Social Infrastructure Assessments
Department of Planning, Industry & Environment
GPO Box 39
Sydney NSW 2001

Application number: SSD-10339

Re: Randwick City Council submission on the State Significant Development SSD-10339 – Prince of Wales Hospital – Addition to approved Acute Services Building for Health Research Use, Hospital Road Randwick (SSD-10339)

**NORTH - SOUTH PEDESTRIAN LINKS**

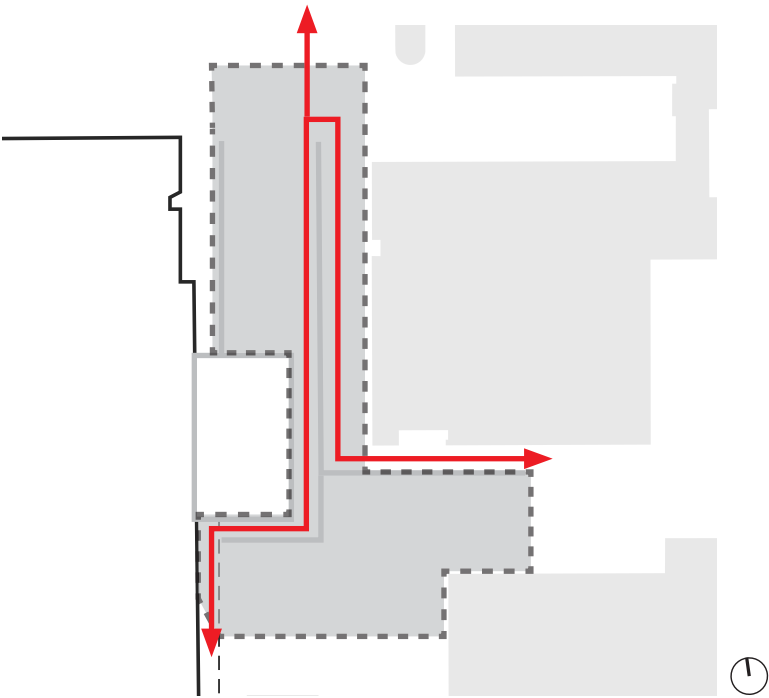
Additional plans and information is required to show how north-south pedestrian access will be maintained along Hospital Road. It is noted in the Precinct Master Plan Structure Plan (pg. 13 of Design Statement) that there is continual access specified along Hospital Road. It is recommended that this be maintained at all times. As a result of this proposal, pedestrian access between the north and south of Hospital Road is only available via a narrow staircase. This raises Disability Discrimination Act (DDA) compliance issues which are particularly pertinent given the nature of this development as a public hospital. Council requests that further information is provided to specify how DDA compliance will be achieved.

# LEVEL 00 Landscape Design

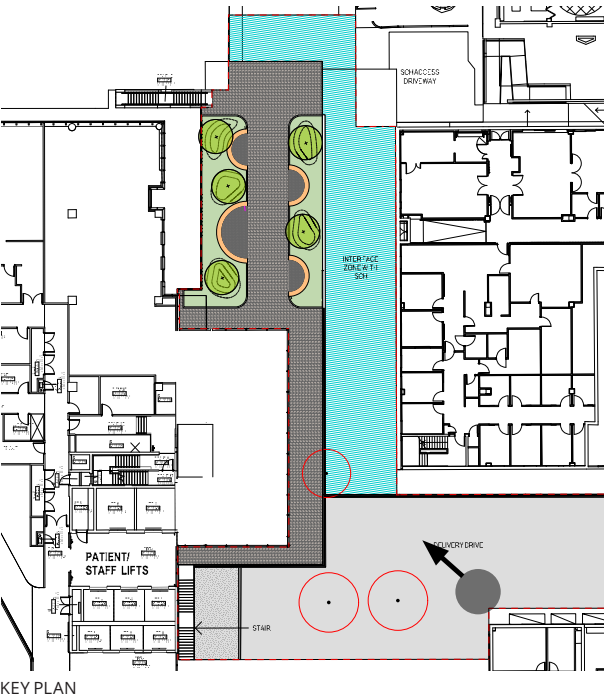
Council recommends that pedestrian and cycling wayfinding signage is provided. In particular, wayfinding signage is critical at the north-east corner of the ASB site at the Level 00 primary pedestrian connection in order to ensure that clear disabled access is provided north to south.

Council notes the Landscape Design Report prepared by ASPECT Studios at Appendix E. As planting incorporating feature canopy trees has been shown at the Level 00 primary pedestrian connection from the north, further details must be provided to confirm that both sufficient soil depth and volume will be provided to sustain the trees for their life term. Further to this, Council requests that the Landscape Design Report is amended to include the following information:

Hospital Road Planting Plan 1:200 @A3

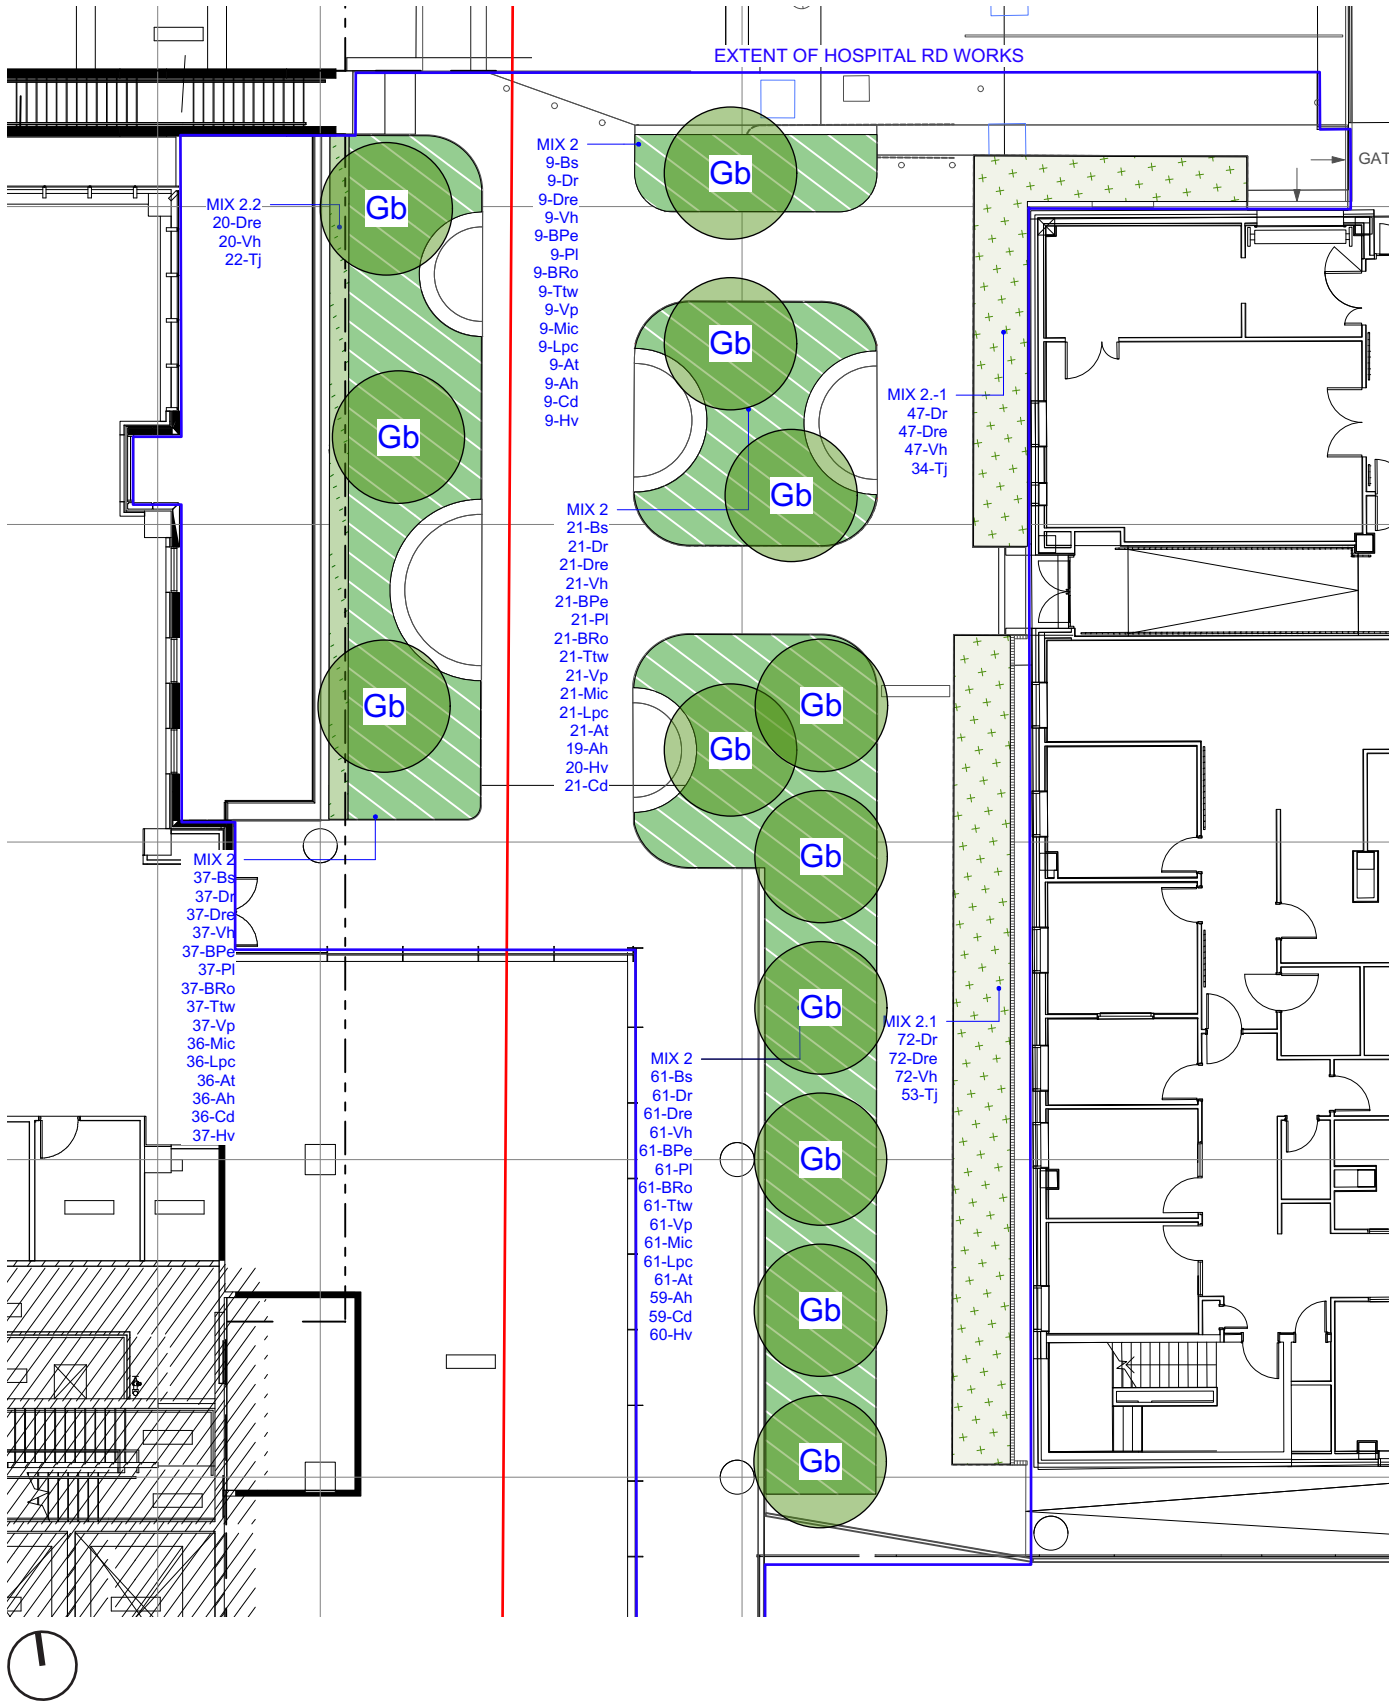
- A planting plan and plant schedule that includes proposed species, botanic and common names, pot size at time of planting, quantity, location, dimensions at maturity and any other details required to fully describe the works;
- A schedule showing the number (as a percentage of total) the endemic, native and exotic species that will be used in all new planting;
- A schedule showing the number of new canopy trees to be planted compared to the number of trees to be removed;
- Lighting strategy for paths and gardens to assist with wayfinding and surveillance/security.
